SSD 6626 - SICEEP Darling Square - Mixed Use Residential Building within North-East Plot

Submission by:

Vaughn and Matilda de Vocht

26 November 2014

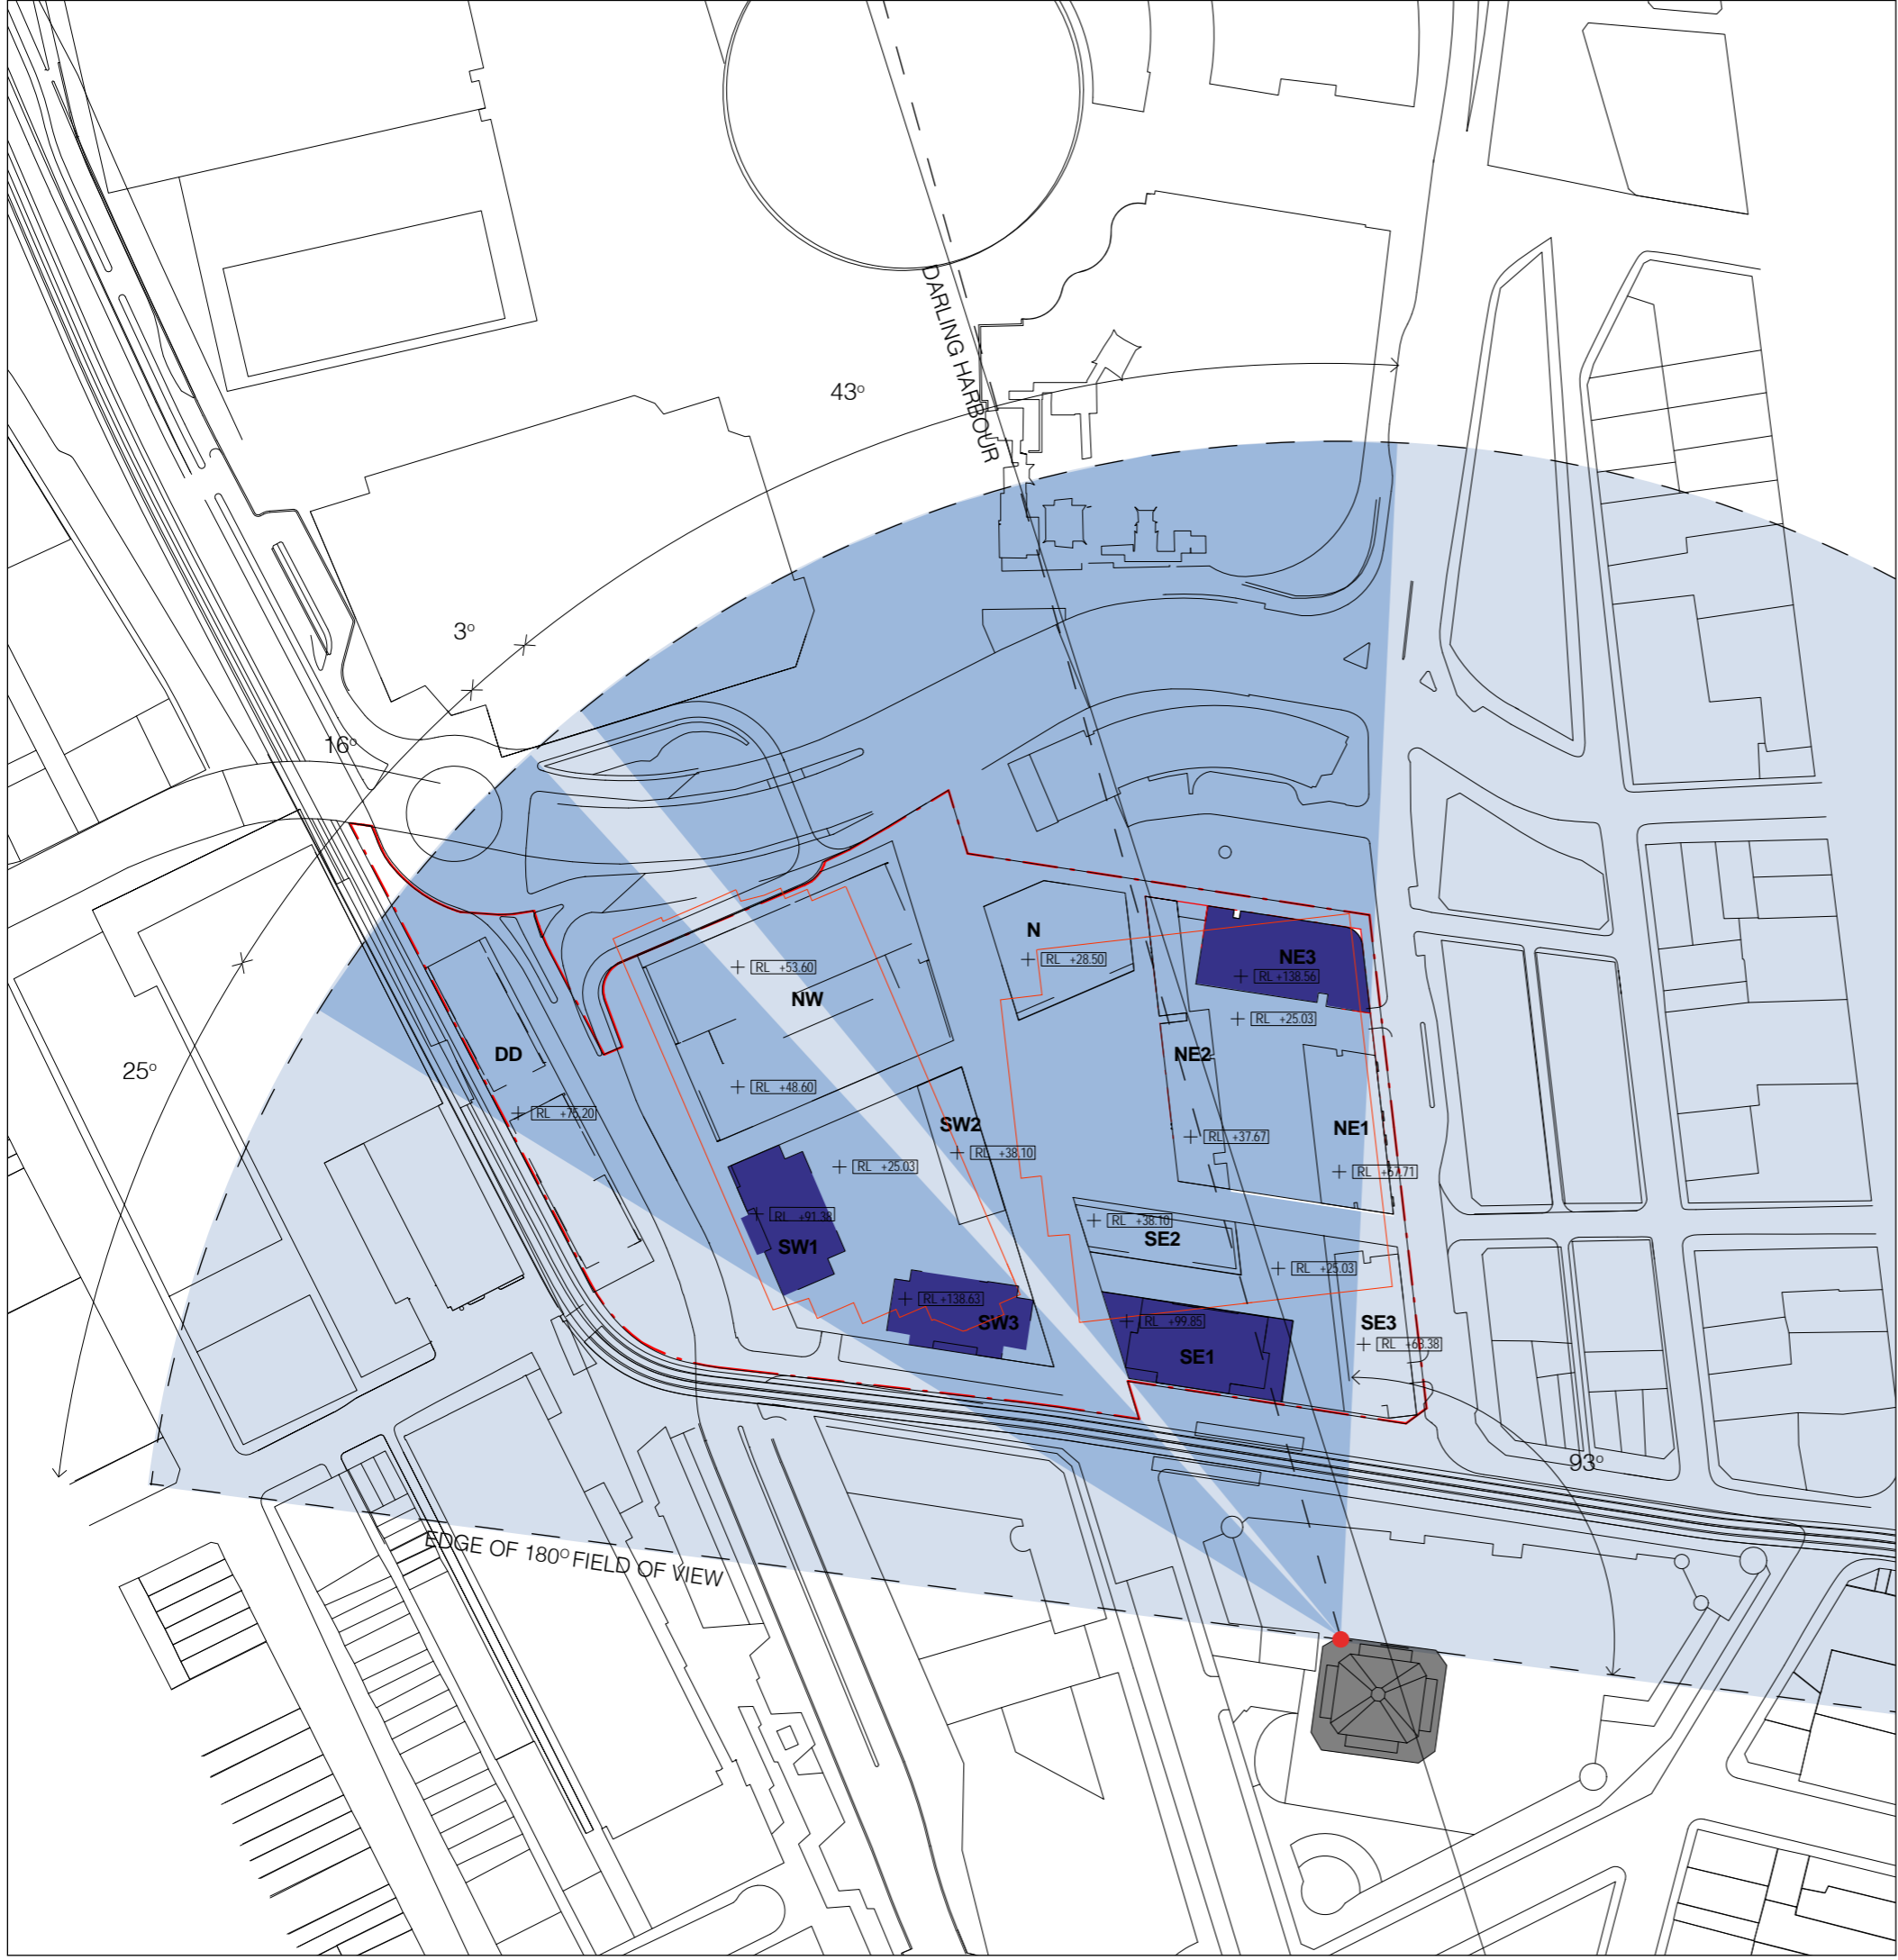
Zero building articulation or view sharing

The NE tower proposal as currently framed is inconsistent with the Department of Planning's November 2013 SSD 5878 determination and with the Residential Flat Design Code (RFDC).
